33 Island Ave. - P.I.

2005-0134
Application I. D. Number

RE: Proposed Amendment to an Approved Site Plan
Inn on Peaks – 33 Island Avenue – Walkway and Ground Leveling
Application #2005-0134

TO: Ethan Boxer Macomber – Planner
FROM: Jim Seymour – Development Review Coordinator, Sebago Technics, Inc.
RE: The Inn on Peaks Island, Island Acquisition LLC
DATE: June 30, 2005

SITE DESIGN
 AND
 FIRST FLOOR PLAN

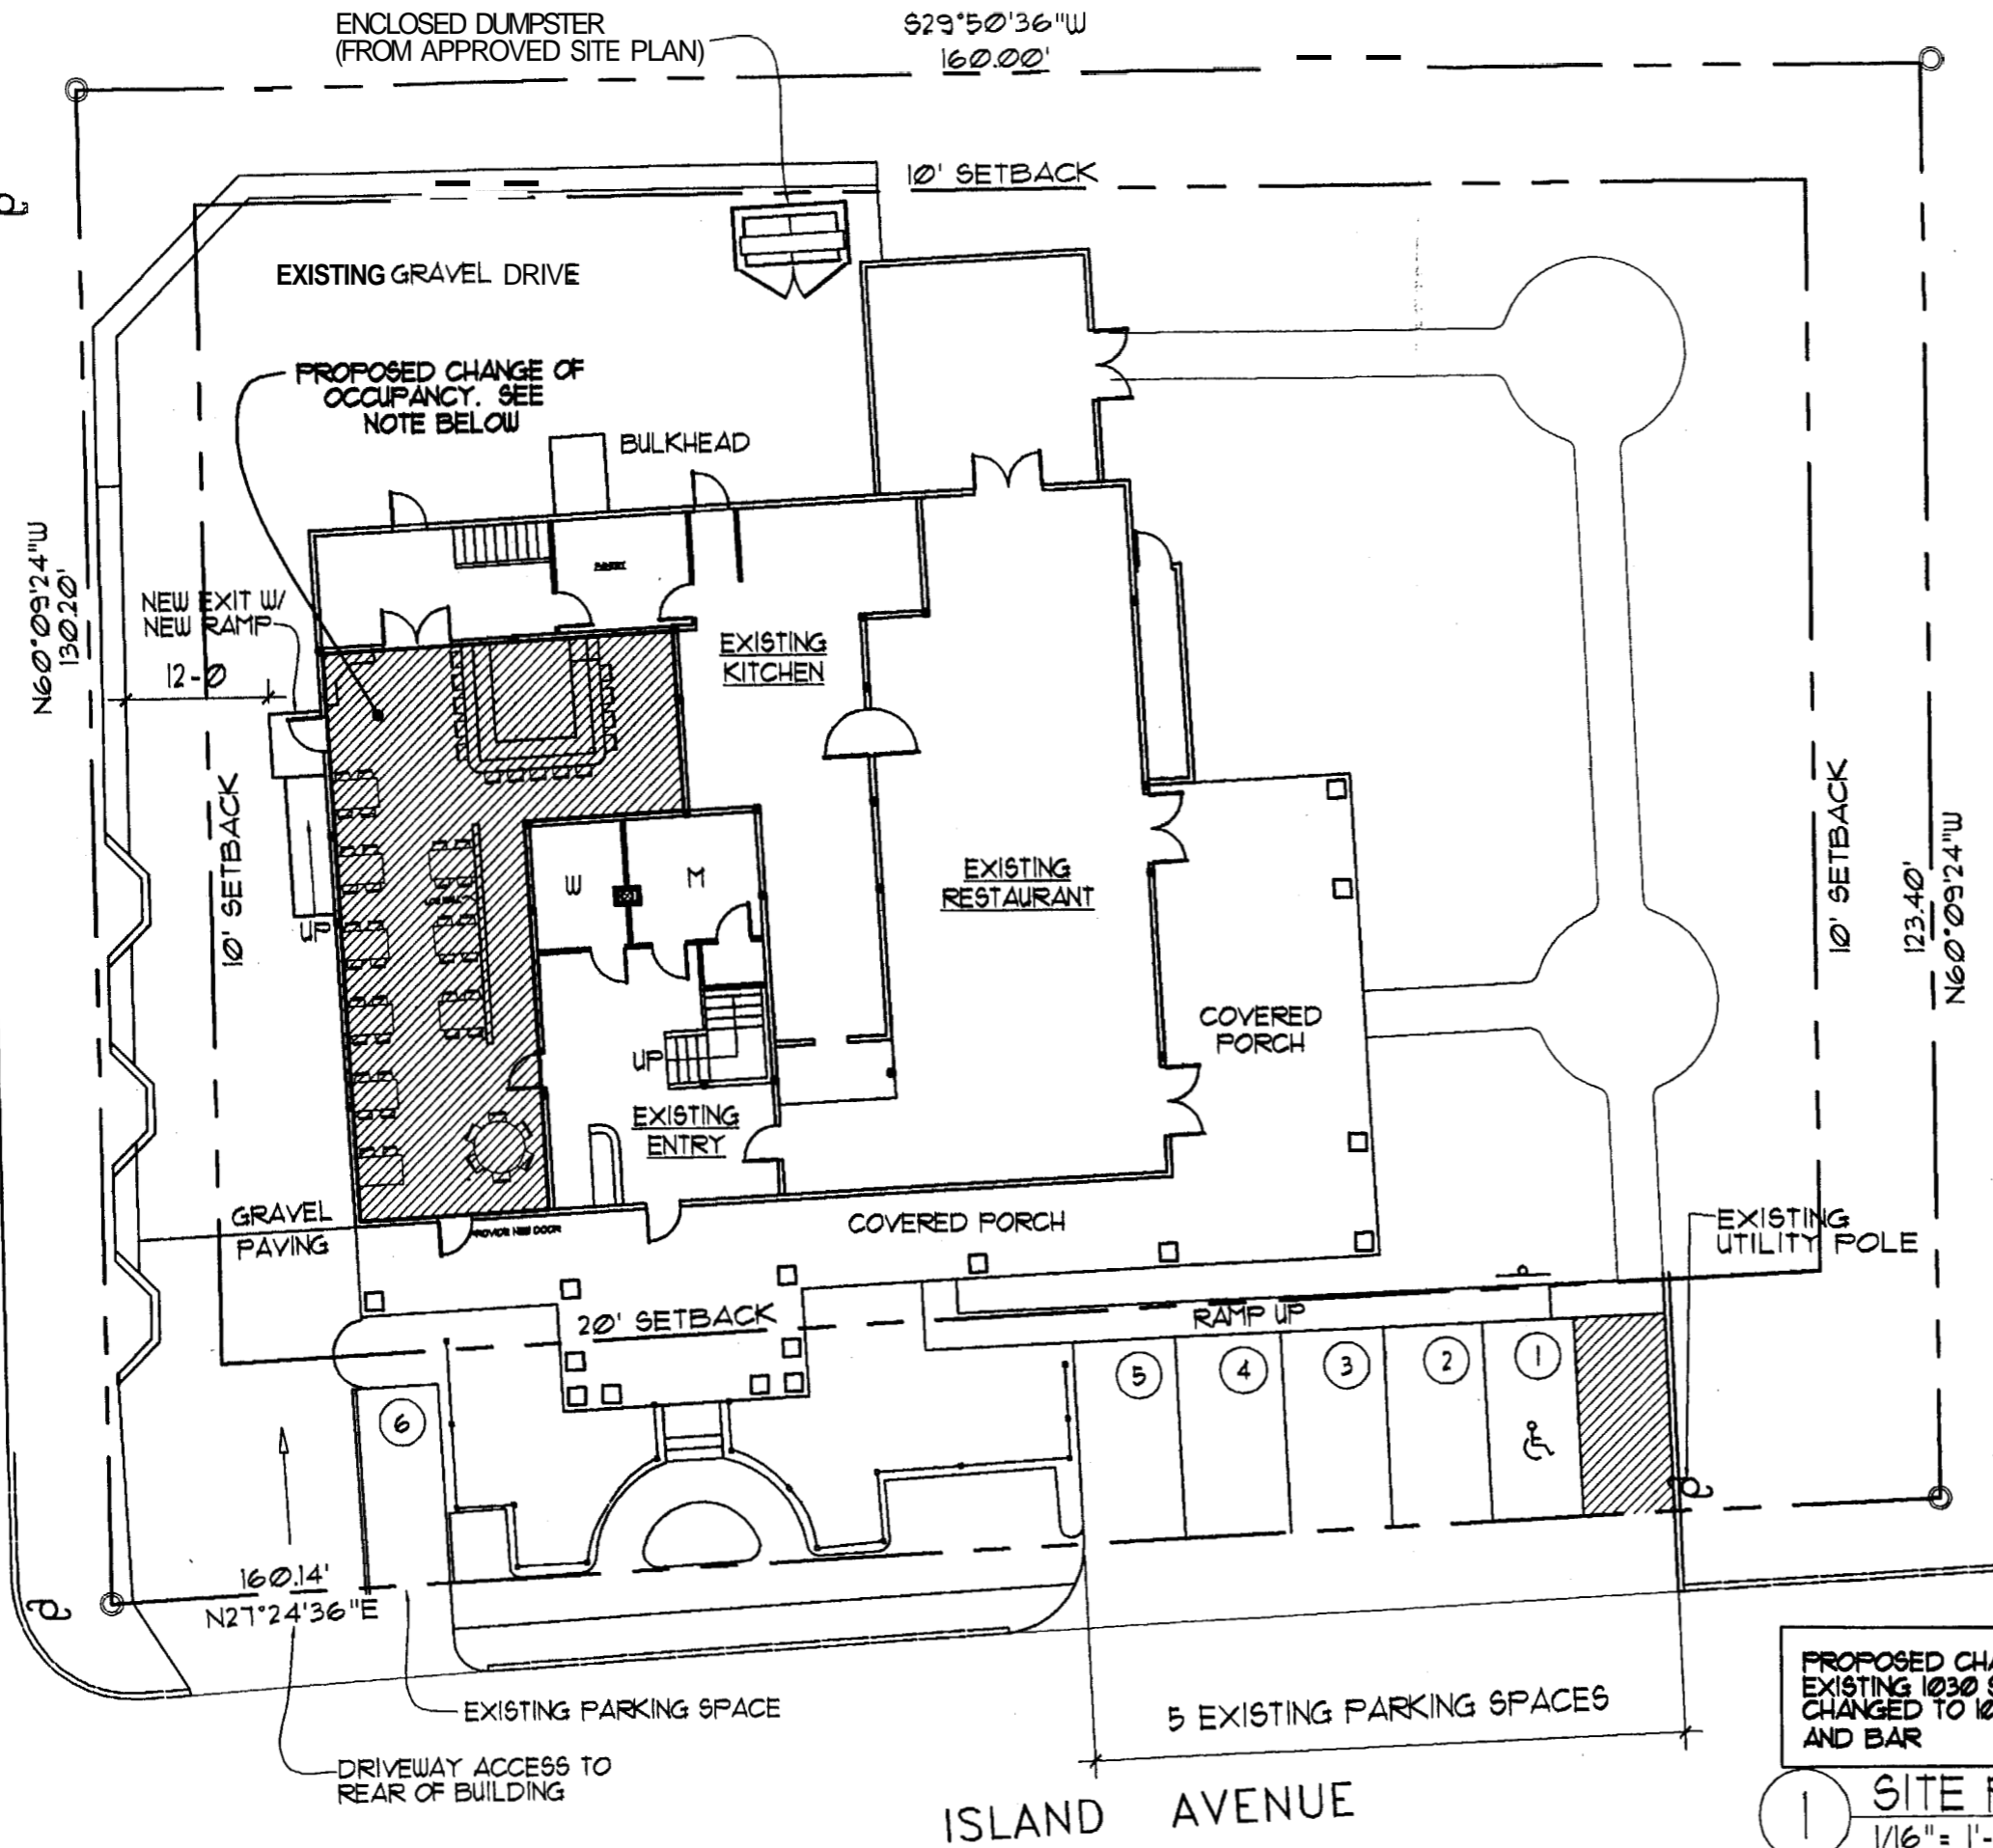
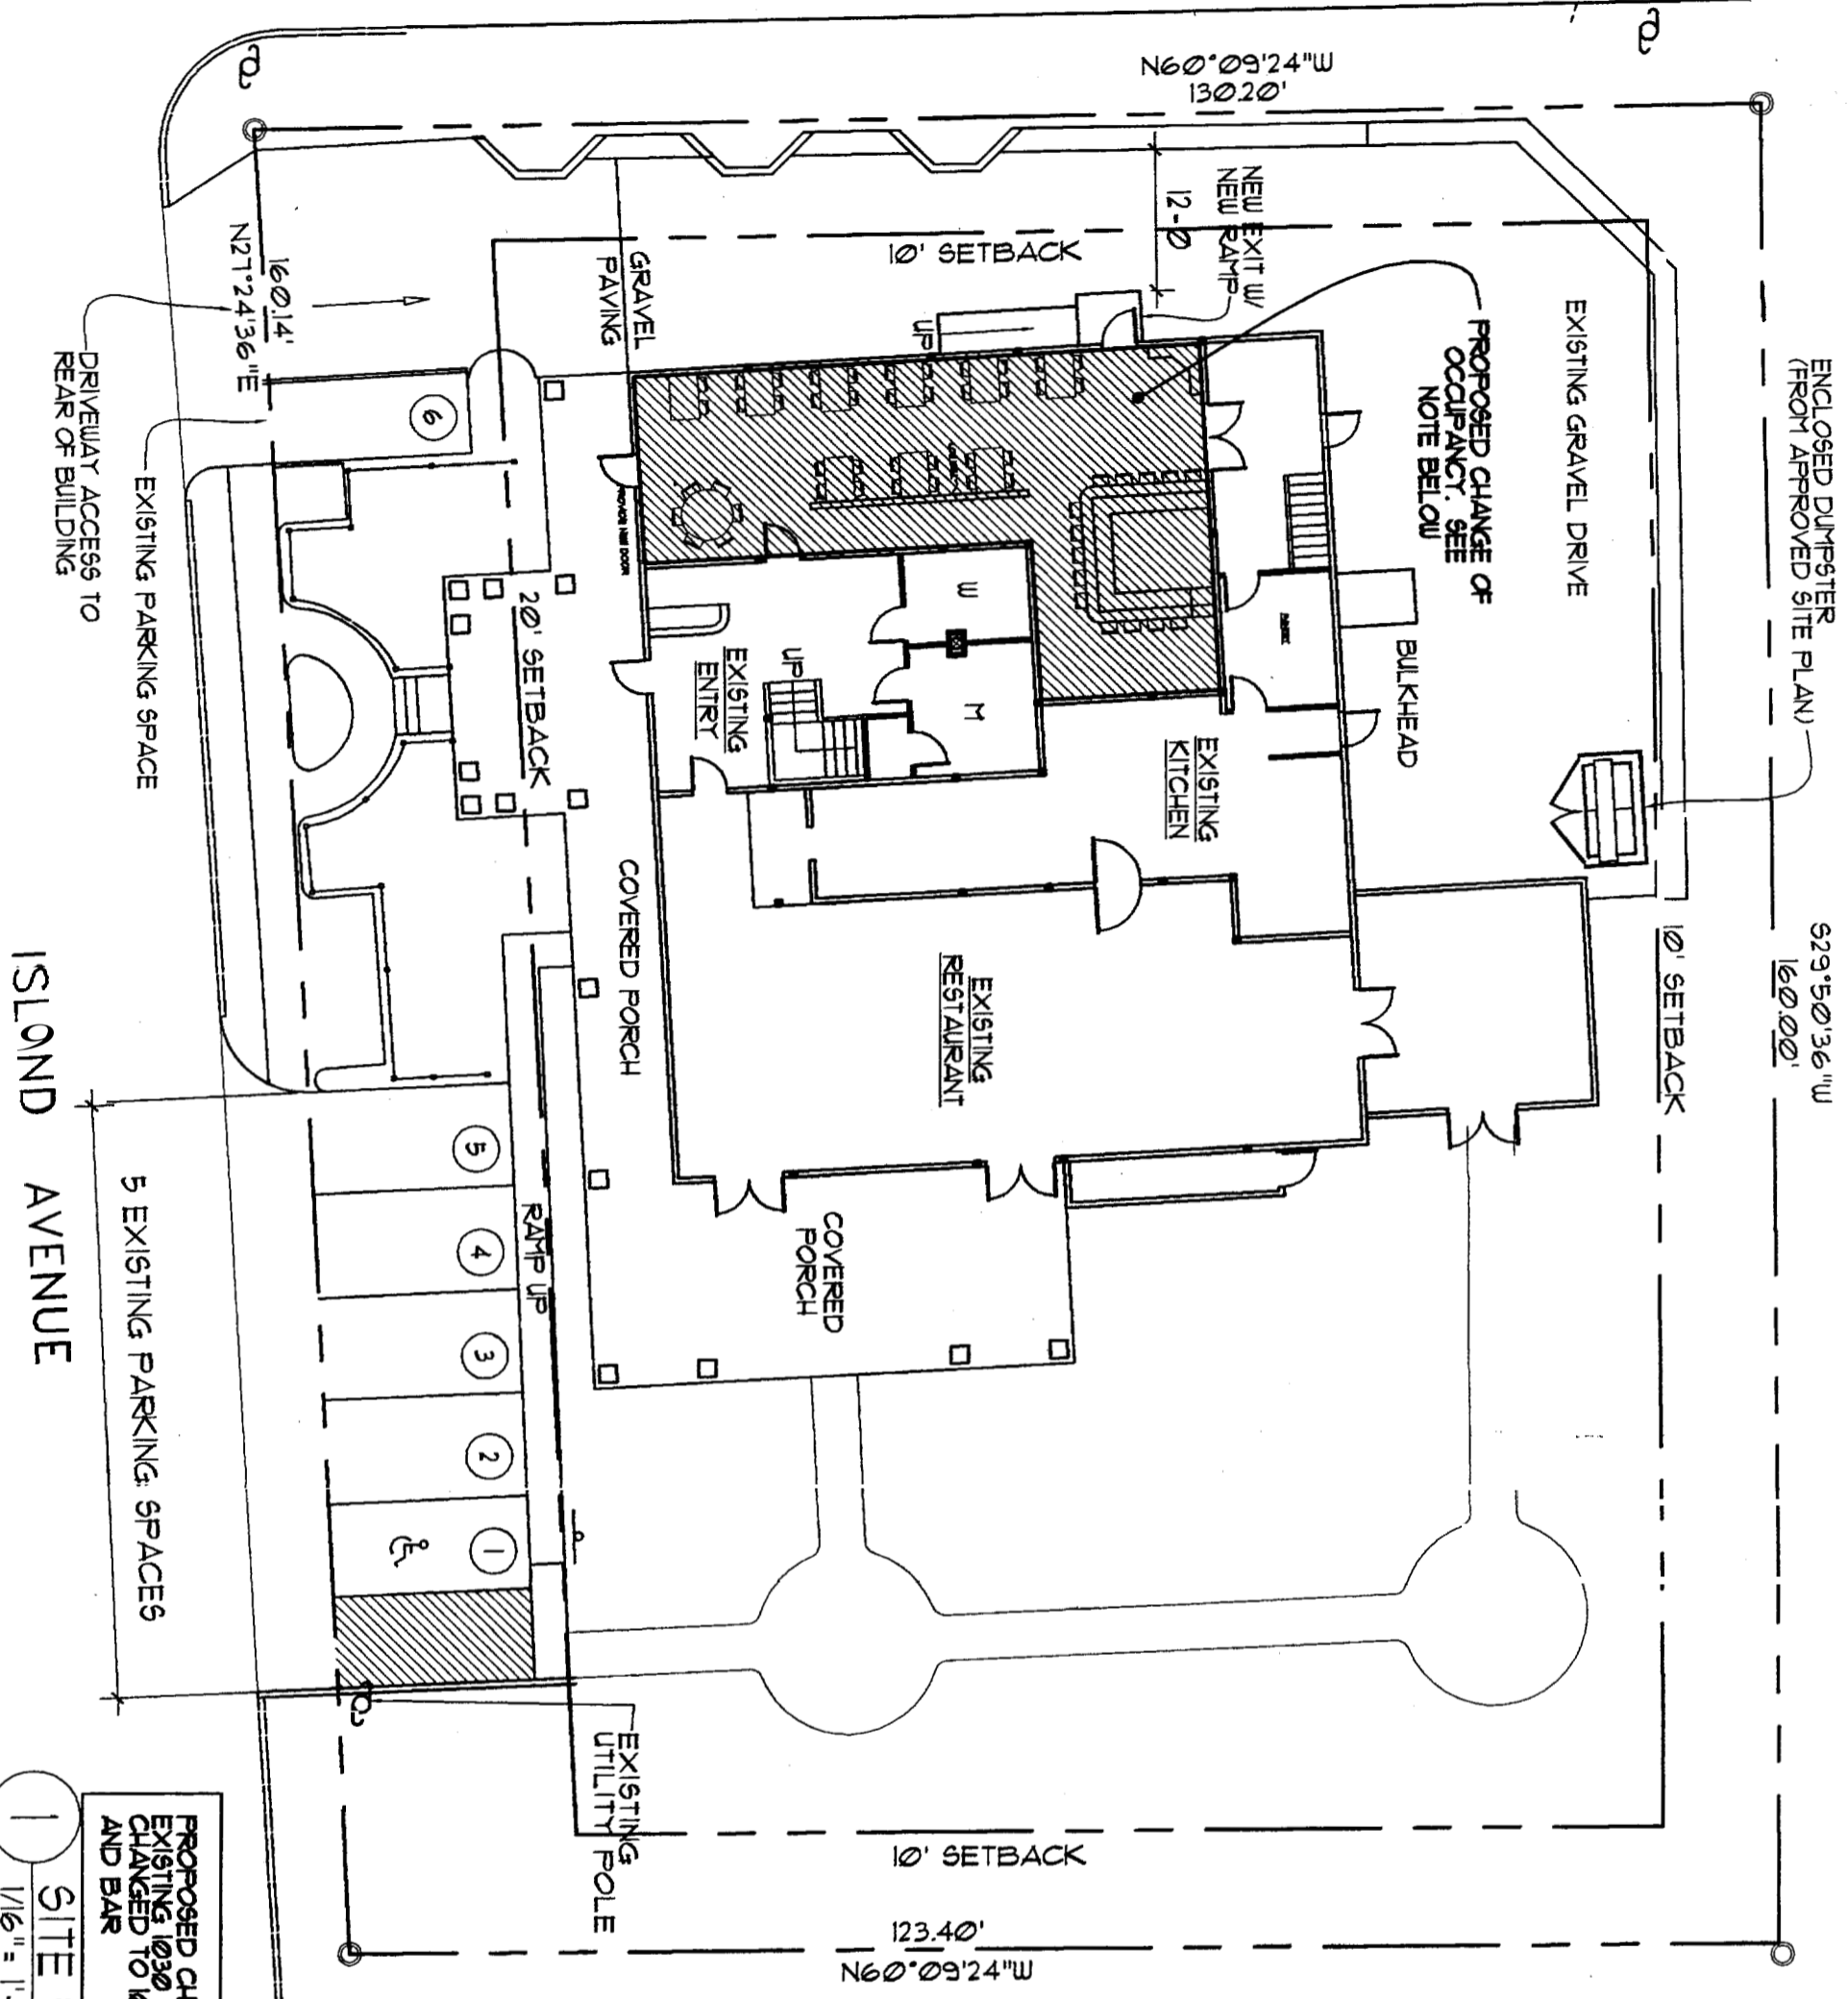
- A. Different plans had different dimensions for figuring the size of the existing building.
- B. This project is in an I-B zone where restaurant uses are permitted. The given analysis is inaccurate. It states that the original approval did not require any parking at that time. That is untrue. Four parking spaces were required. More than four spaces were shown so it was not a zoning issue.

- D. The site plan given to determine zoning is inaccurate. The tent hangs over an existing porch in order to meet the setback requirements (ten feet to the side property line). In real space on the face of the earth, that can only mean that the 40' x 80' tent cannot meet the setbacks when placed on site. Perhaps a narrower tent should be considered.

- E. I have also computed the lot coverage. I differ from what has been submitted. The project has only 80 square feet to spare. I would like to confirm building dimensions since different plans scale to different dimensions. Because they are almost right on their maximum lot coverage requirements, I want to be absolutely accurate on my calculations. I would want accurate scaleable plans submitted confirming the current dimensions of the existing building.
